Rezoning Transportation Analysis

Petition Number: 2020-134

Date	Description
10-20-2020	First Review (KP)
11-30-2020	Second Review (KP)

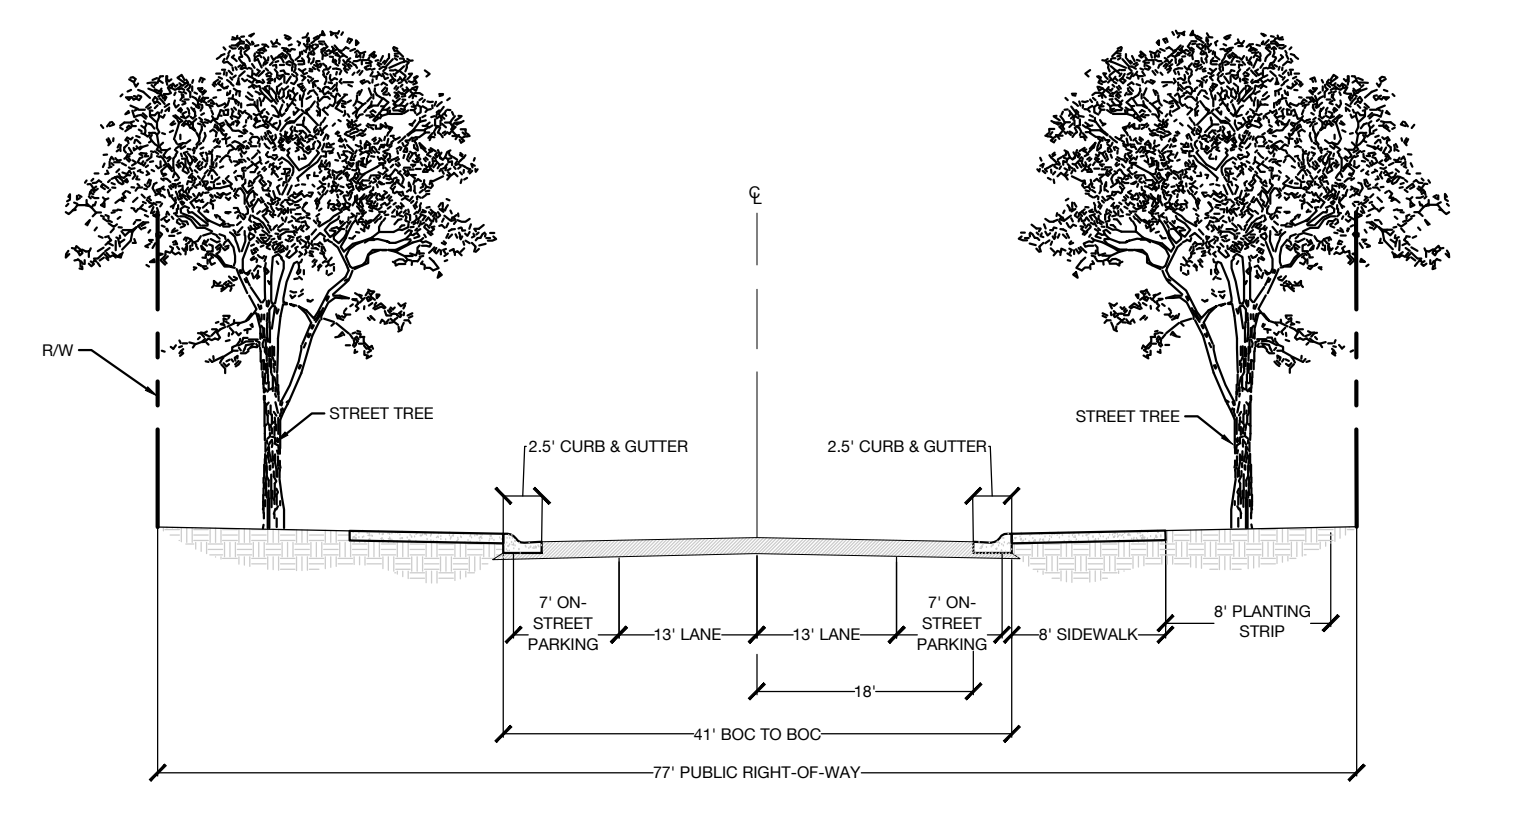
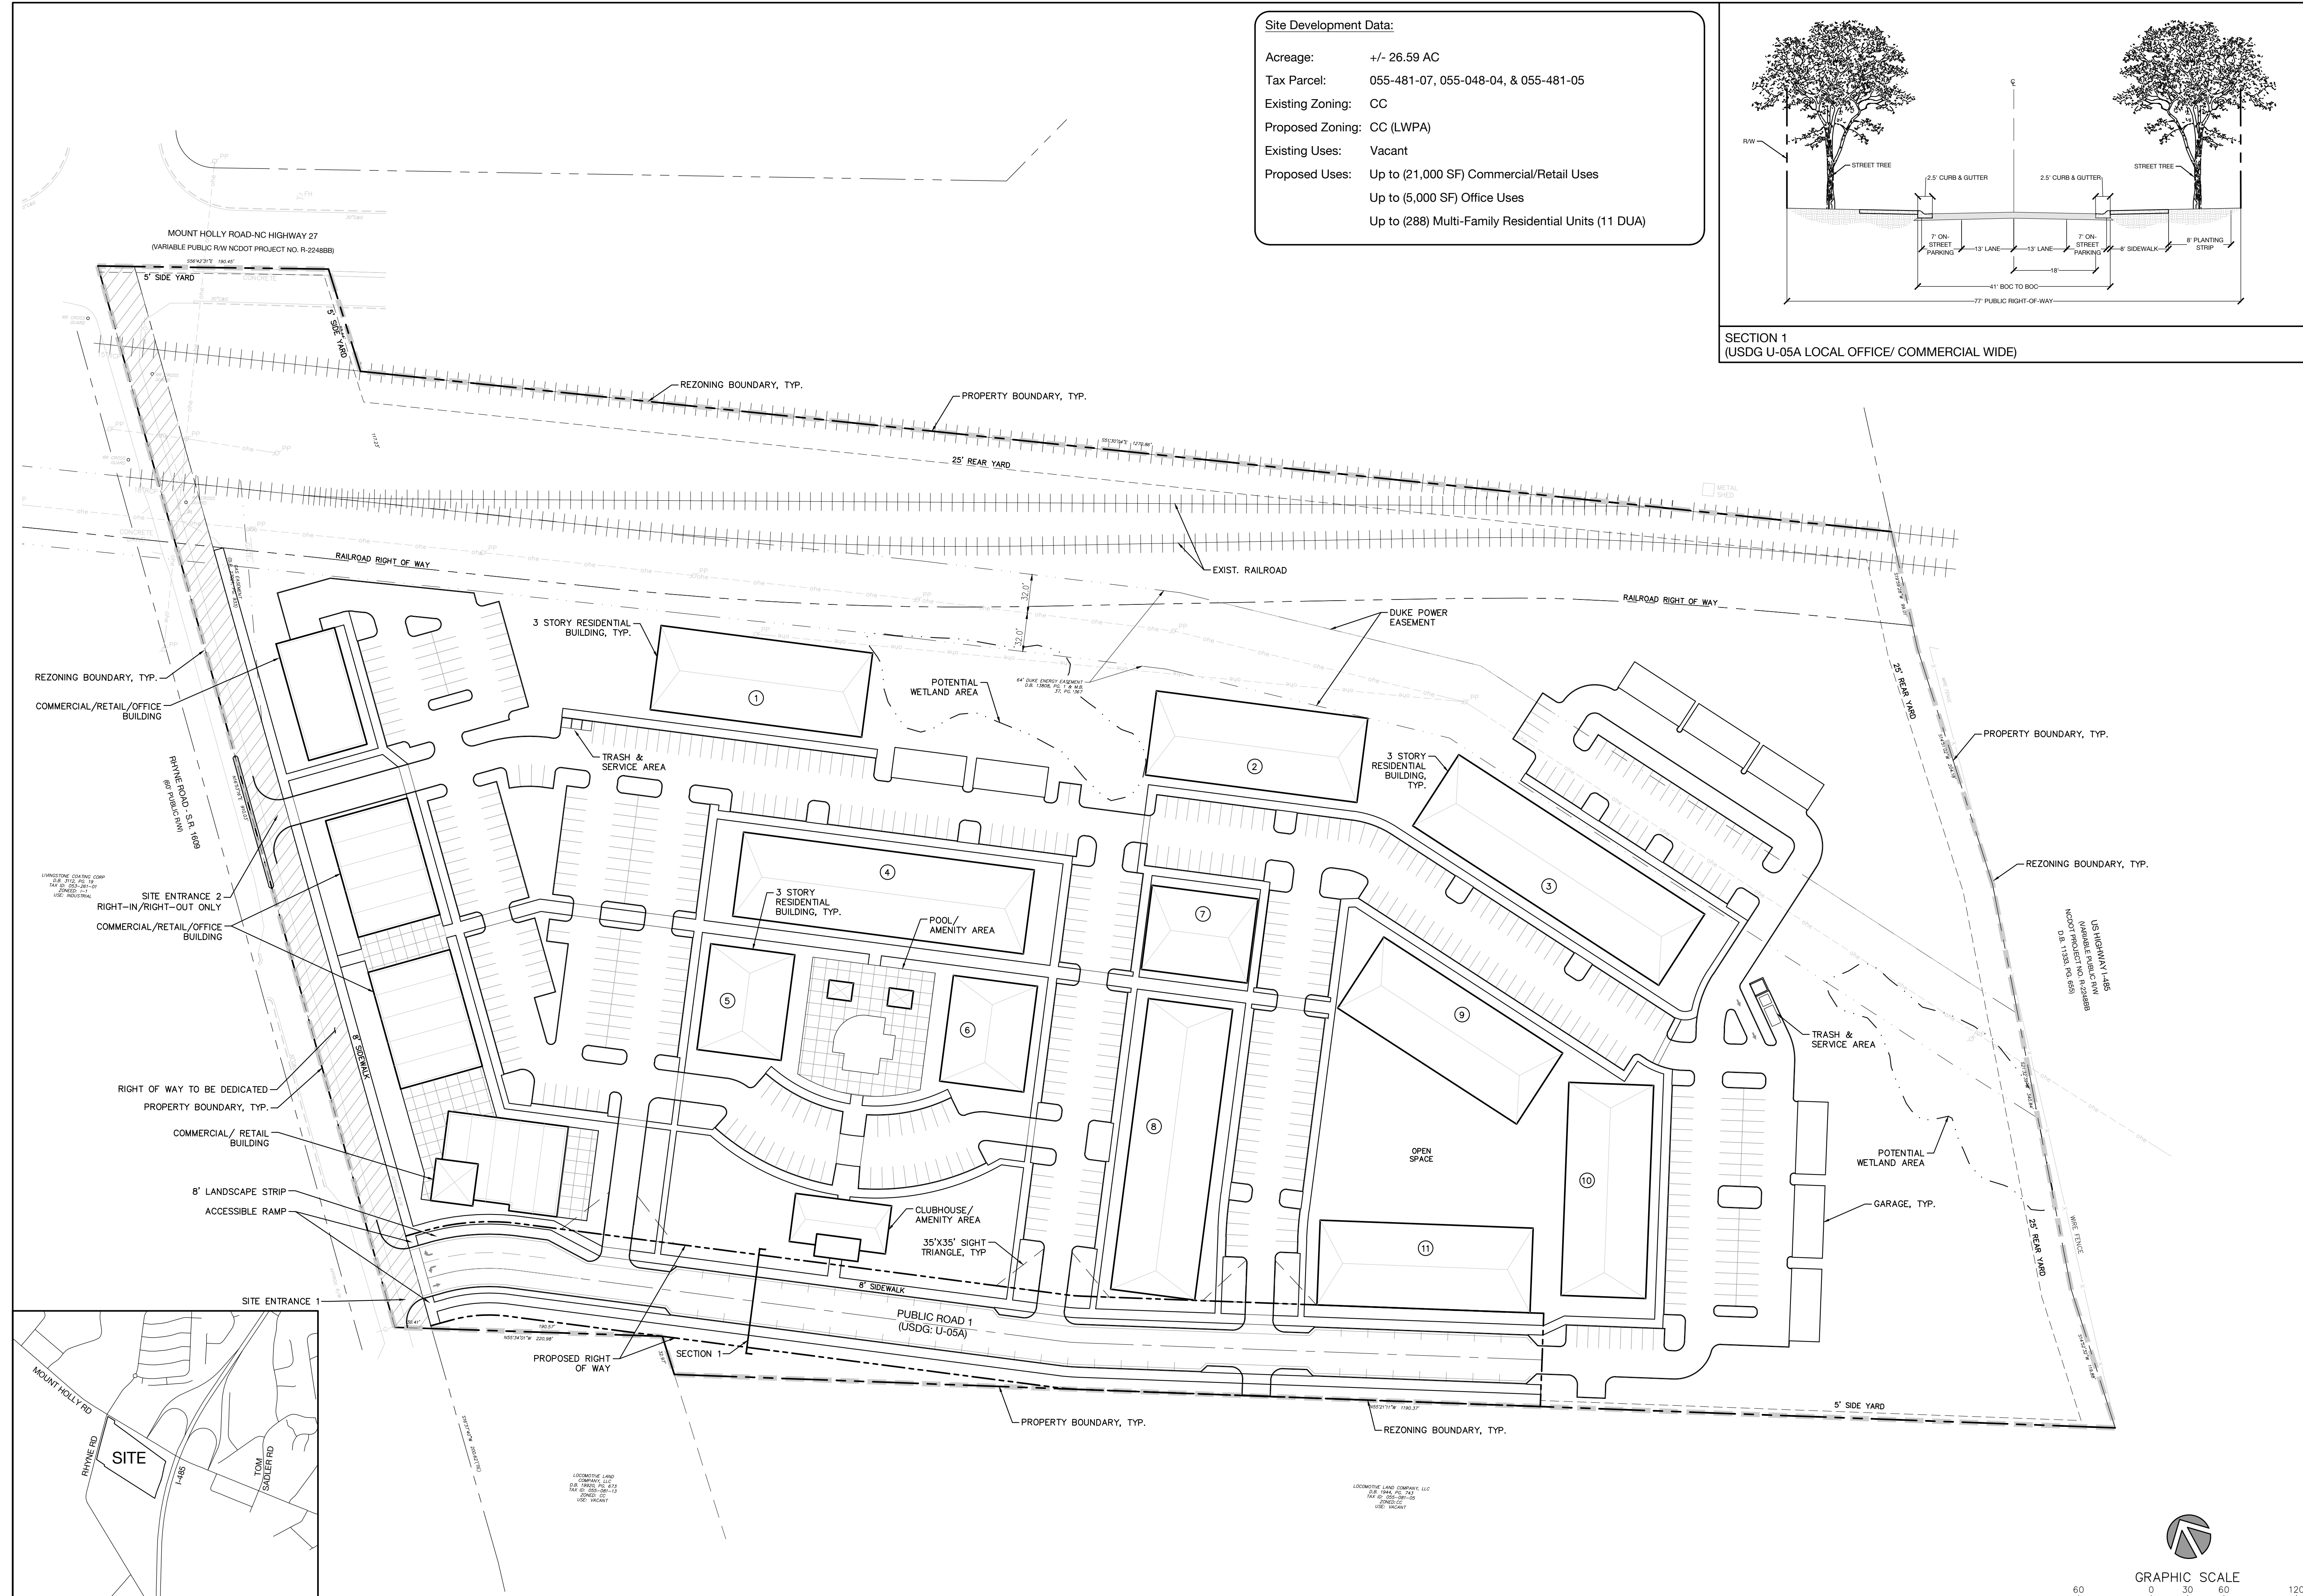
1. Curb line:

- a. **Mt. Holly Road:** The future location of curb and gutter will be located 33-feet from centerline to the back of curb.
- b. **Rhyne Road:** The location of curb and gutter will be located 19-feet from centerline to the back of curb.

Label and dimension the curb and gutter from the centerline for each road.

3. Right-of-Way Dedication:

- a. **Mt. Holly Road:** Revise the site plan and conditional note(s) to commit to dedicate 55-feet of right-of-way from the road centerline. **Update as a result from 11-16-2020 Site Plan: Dedicate as much ROW as possible without encroaching into the Railroad ROW.**
- ~~b. **Rhyne Road:** Revise the site plan and conditional note(s) to commit to dedicate 41-feet of right-of-way from the road centerline. **Update as a result from 11-16-2020 Site Plan: 40-feet of ROW dedication is acceptable.**~~

The site plan should label and dimension the right-of-way from the road centerline.

4. Revise the site plan and conditional note(s) to commit to construct an 8-foot planting strip, and 12-foot multi-use path along the site's Mt. Holly Road and Rhyne Road frontages per Chapter 19 and the City's WALKS and BIKES policies. The site plan should label and dimension both items from the back of curb and gutter and road centerline.

5. Revise the site plan to show, label, and dimension the center lane median, on Rhyne Road, in front of Site Entrance 2, that will direct the right-in right-out movement(s). Also, include the commitment to construct this center lane median in the conditional notes.

6. Revise the site plan and conditional notes to commit to the construction of a three-lane cross section, as shown below, along the site's Rhyne Road frontage. Add to the conditional notes that center turn-lane storage and tapers will be coordinated with NCDOT during plan permitting.
 - a. ***Advisory Comment***: In accordance with the construction of the 12-foot multi-use path as noted in item 4 of this CDOT memo, the 5-foot bike lane, as depicted in the cross section below, may be excluded.

Update as a result of the 11-16-2020 Site Plan: Add a conditional note stating that the 12-foot MUP will be extended across the railroad and connected to the bicycle pedestrian infrastructure constructed as a part of the Mount Holly-Sonoma Valley/Rhyne Road Intersection Improvement Project. This MUP connection will coincide with the intersection improvement project and will be coordinated with NCDOT.
